Large-scale Residential Development 'Swift Square Apartments'

MH21009
F01
July 2023

APPENDIX 2.1

LRD - SECTION 247 PRE APPLICATION CONSULTATION NOTES

APPENDIX 10.1: SHADOW STUDY DIAGRAMS
SWIFT SQUARE APARTMENTS • LANDS LOCATED TO THE NORTH OF SWIFT SQUARE OFFICE
PARK AND NORTHWOOD AVENUE, SANTRY, DUBLIN 9
MARCH 2023

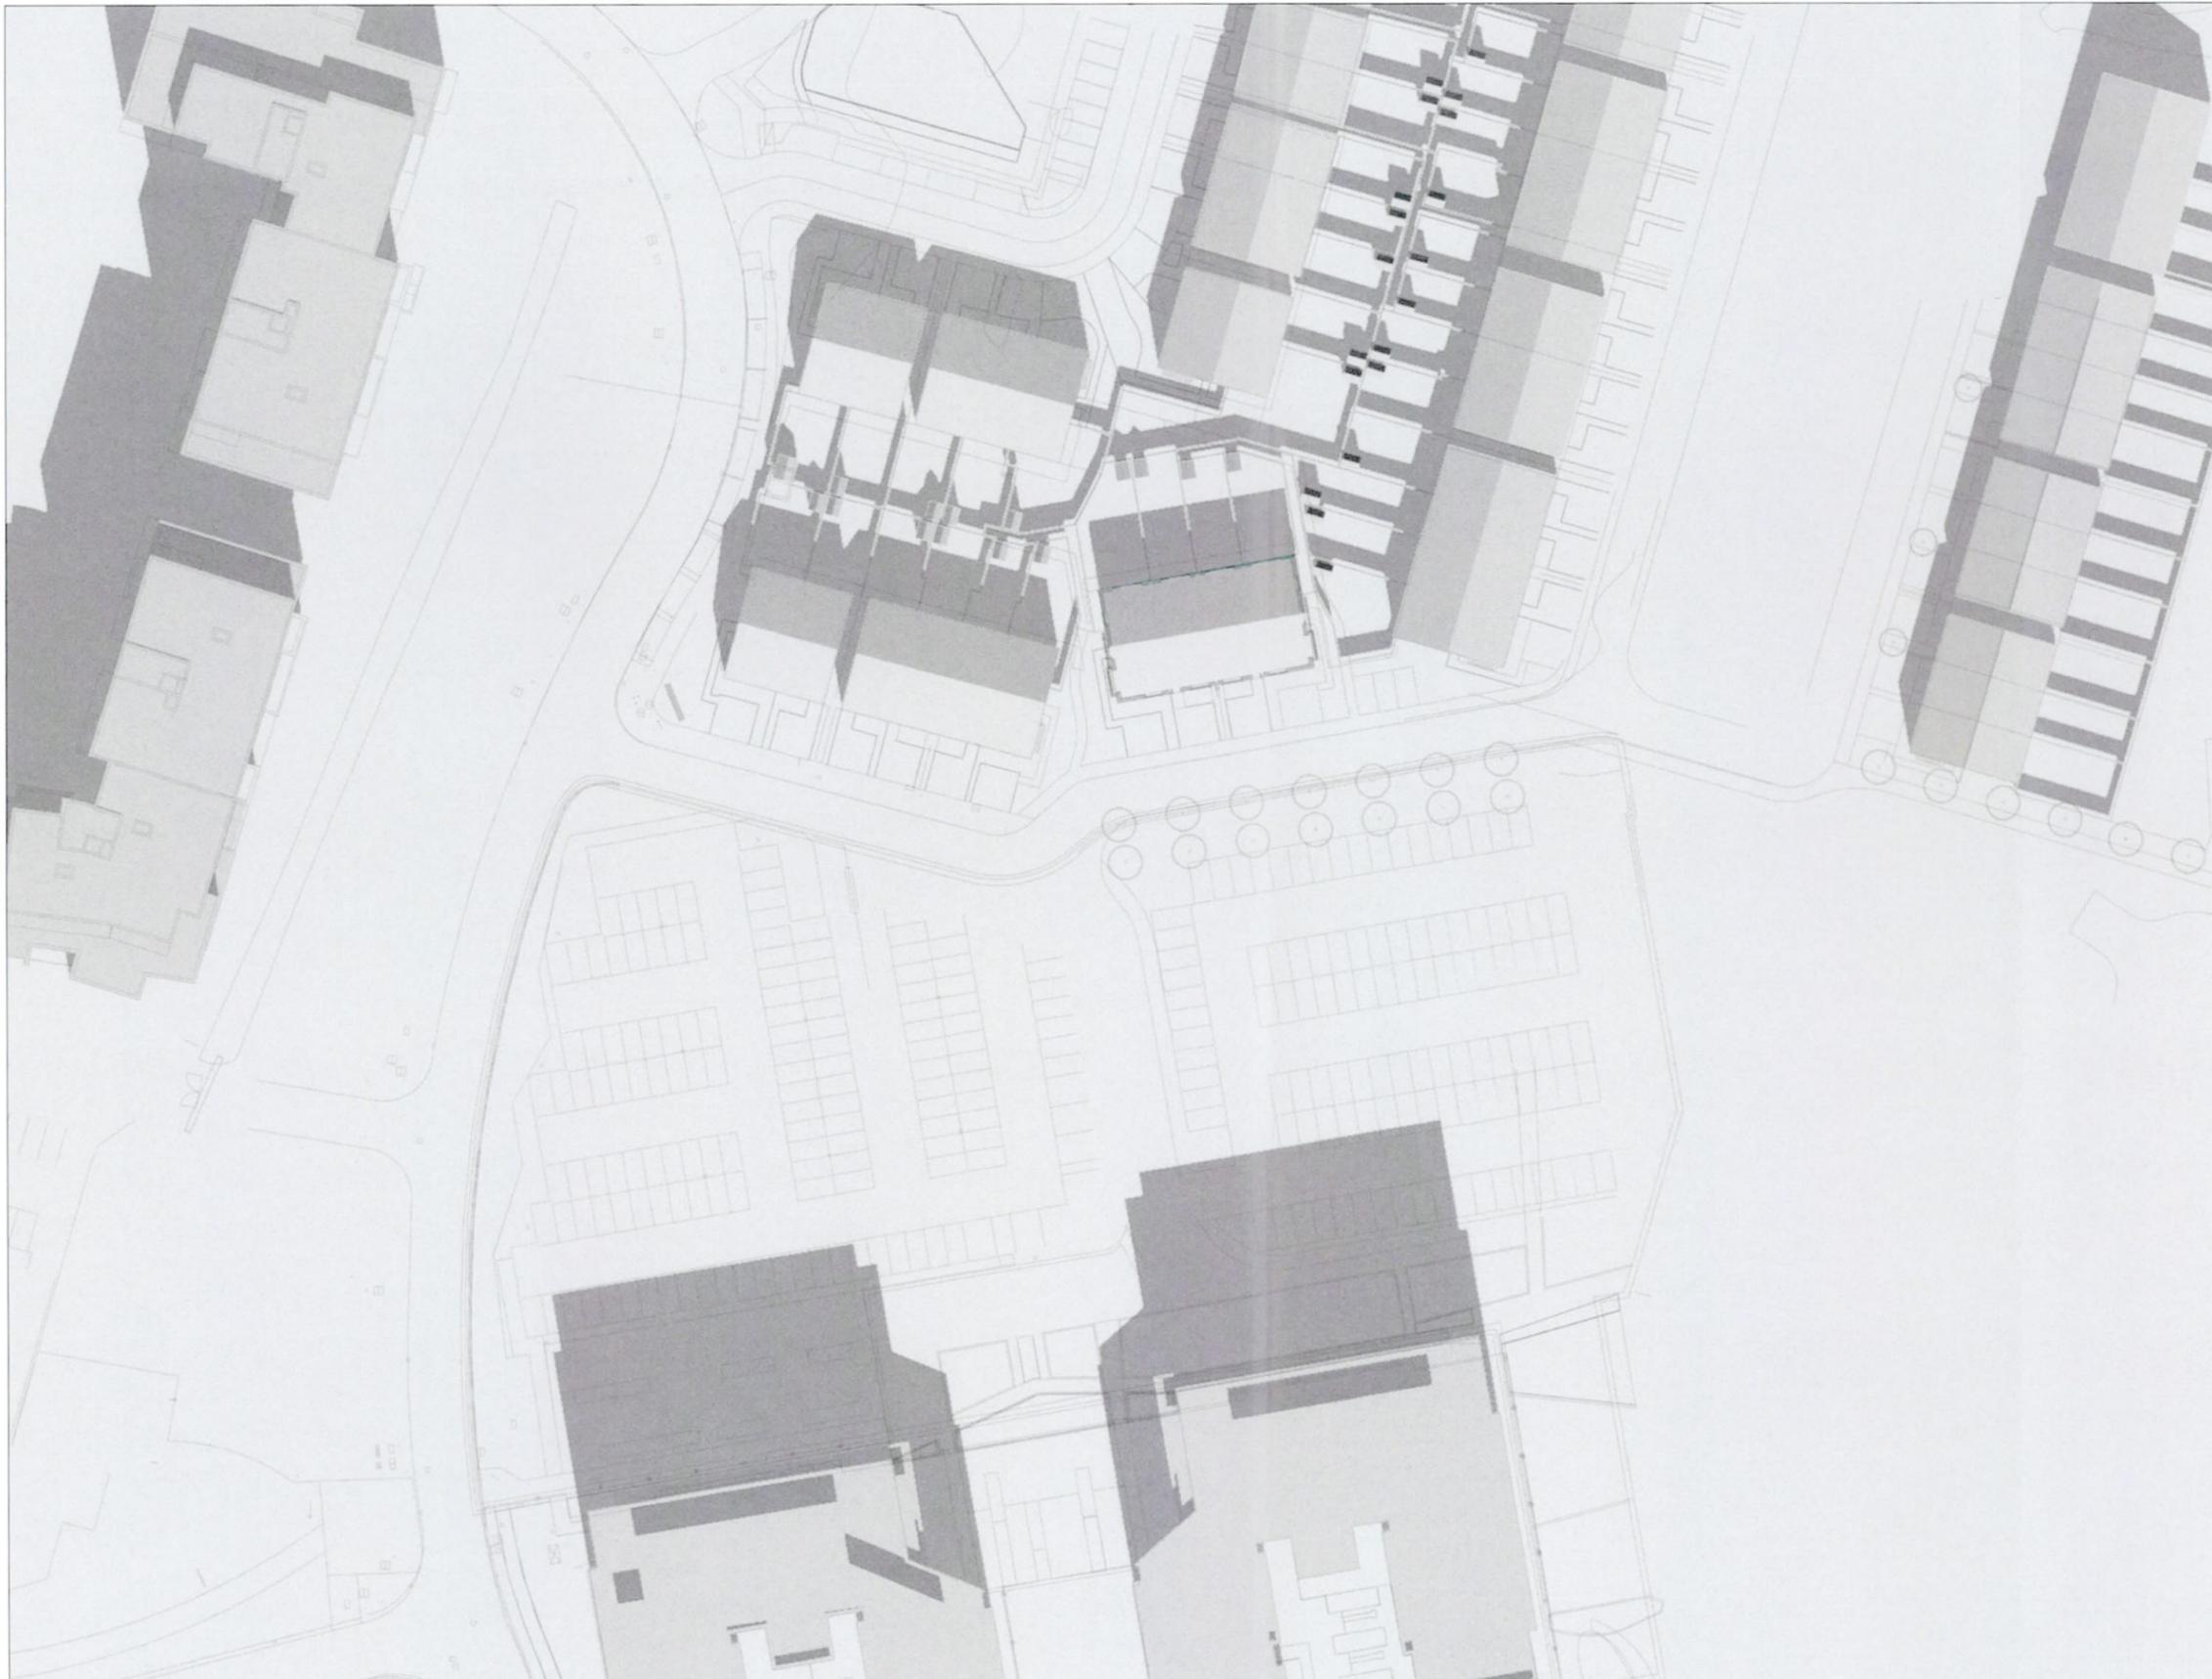
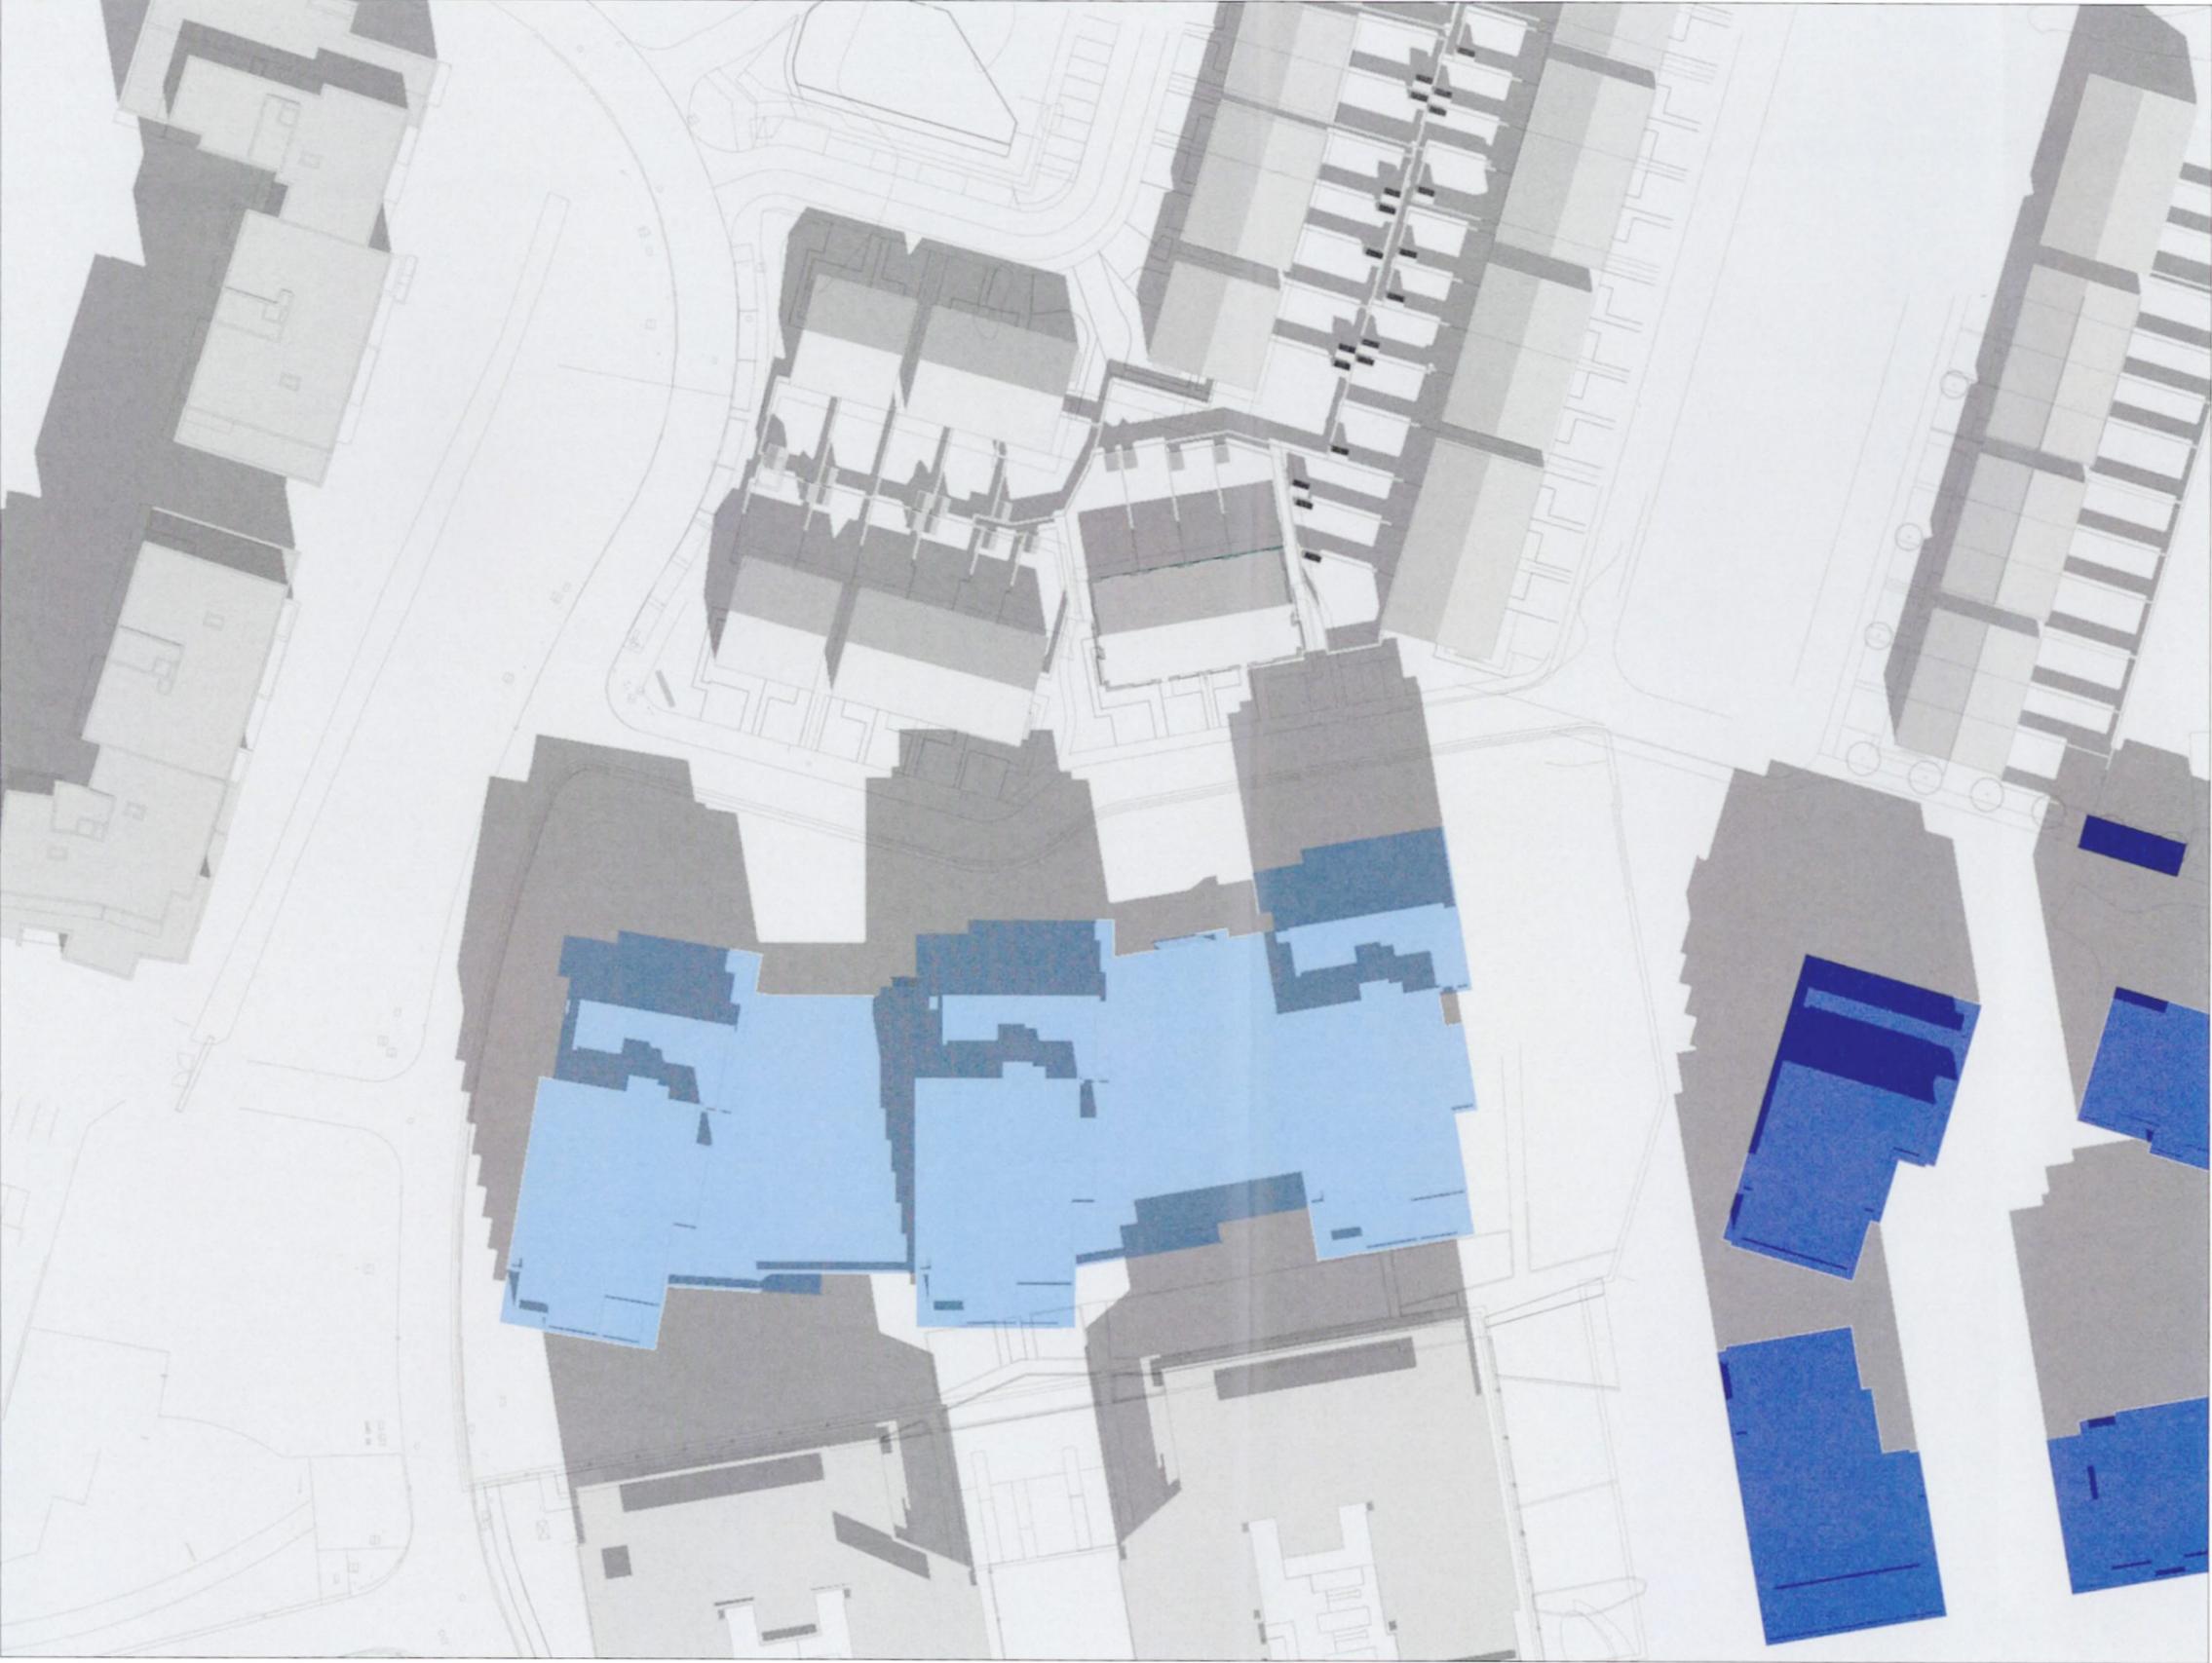
shadow analysis required –analysis to demonstrate light to gap between buildings and ADF to lower units, Overshadowing of open spaces a concern

The impacts of overshadowing on both the proposed units and the spaces are to be taken into careful consideration in the final proposal.

- Southern elevation is much improved. The pop up corners to the west welcomed.
- At the northern elevation the separation distance from Block 1 and Cedarview is 34m & the distance between Block 2 and Cedarview is 21.4m.
- Review potential to reduce the height of the block at the 21m point
- Review and refine fenestration on the northern elevation.
- Applicant should clarify the overshadowing impact on Cedarview in next proposal.
